| Application number: 2025/92713 | |
| Address of the site or building: | Rear of, 23 to 43, Moor Lane, Gomersal, Cleckheaton, BD19 4LF |

2025/61/92713/E

Reserved matters application pursuant to outline permission 2023/92079 for erection of residential development of 10 dwellings, demolition of existing extension at 27 Moor Lane, widening of existing access and realignment of boundary walls and discharge of details reserved by conditions 4 (noise), 5 (BEMP), 6 (Arboricultural Impact Assessment), 7 (safety and security), 8 (landscape), 9 (LEDS)

PROPOSED SITE PLAN 1:200 @ A1

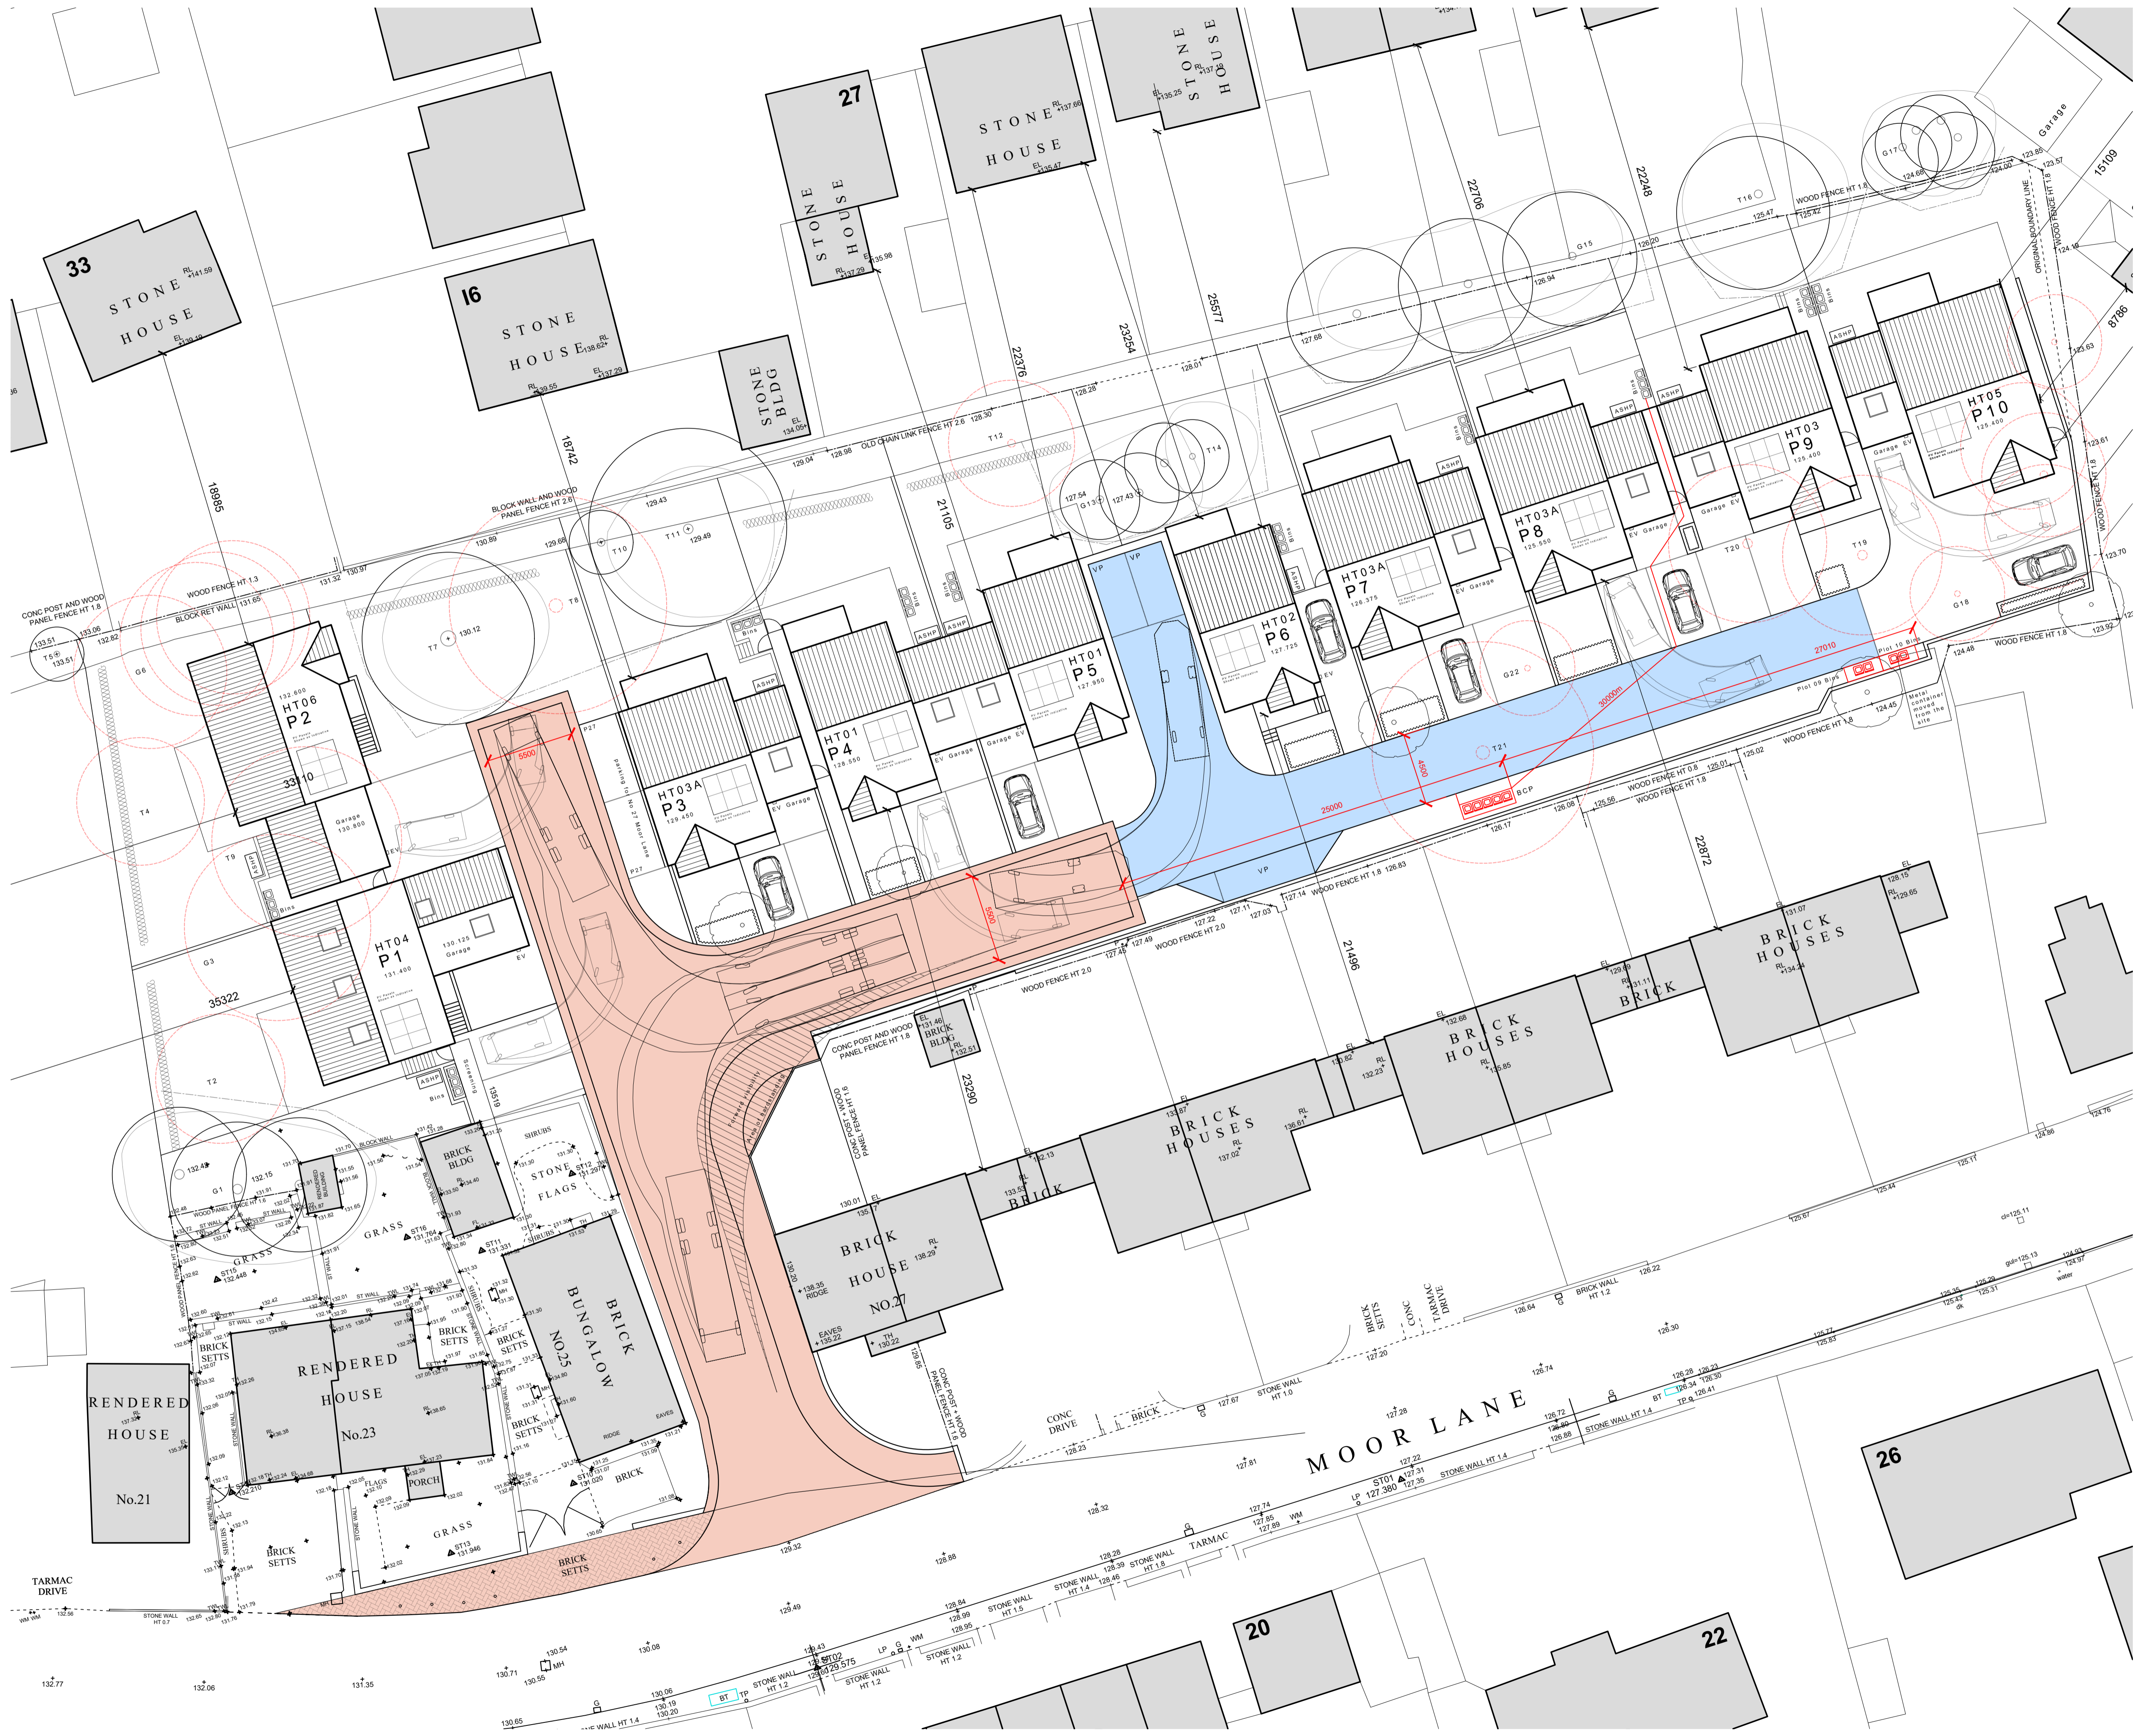
This document states "The existing driveway serving No. 27 Moor Lane is proposed to be relocated slightly to the east and an existing single storey side extension on the property is also proposed to be removed to accommodate the new access. Where the access meets Moor Lane, visibility splays of 2.4m x 23.0m are proposed to be provided in both directions."

The above proposal statements included in this Planning Statement are incorrect.

- 1) No driveway being provided to No 27 Moor Lane.
- 2) A visibility splay of 33 m is required in both directions

Therefore this planning application 2025/61/92713/E is not meeting the Highways Plan Visibility Splays requirements approved in the outline planning application.
